From: Tim Townsend [REDACTED]
Sent: 01 November 2021 08:17
To: Tilly Whishaw [REDACTED]
Cc: Chris Pratt [REDACTED] Michael Eastham <Michael.Eastham@arun.gov.uk>
Subject: RE: BN/119/21 - Angels Nursery, Yapton Road, Barnham

Subject: RE: BN/119/21 - Angels Nursery, Yapton Road, Barnham

Michael at Arun has consulted me for comments in response to the above planning application – in particular, parts of the internal layout, S278 works, Travel Plan etc. He has sent me replies to my first response to the application and I have been looking at those.

19812-GS-Z1-XX-DR-C-2081

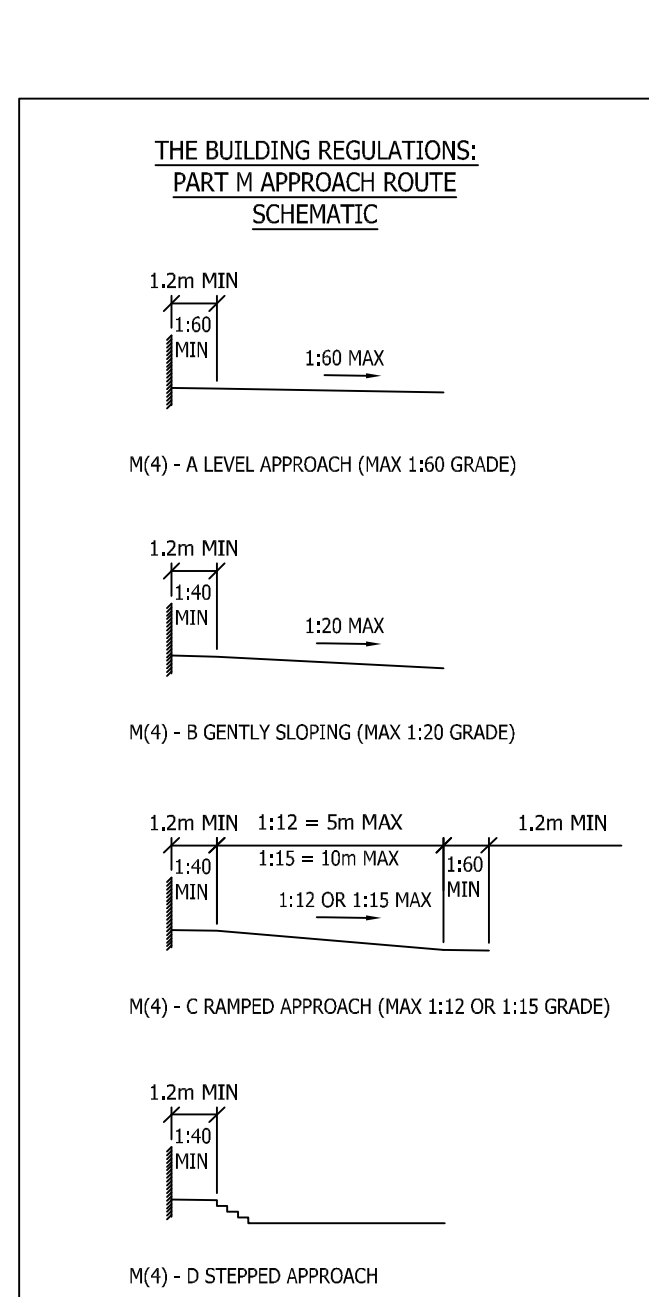
The only apparent outstanding point seems to be with the tie-in point of the cycle/footway as shown below (extract from plan showing how you currently propose things) and as such, I thought it maybe more expedient to approach you directly to try to resolve things:

As shown, it will be particularly difficult for a cyclist to enter or leave the road without overriding the corduroy paving, the tactile paving and part of the ramp. To rectify this would require the corduroy and tactiles being moved southwards and markings provided on the path and – if possible and agreeable with our S38 engineer - on the road away from the ramp. On earlier versions of the internal layout the entry and exit point for the path was further west around the corner and away from conflict points so this might be another option for you/your engineers to consider.

I'd be grateful if you would look into this and provide me with an amended arrangement as soon as possible, please.
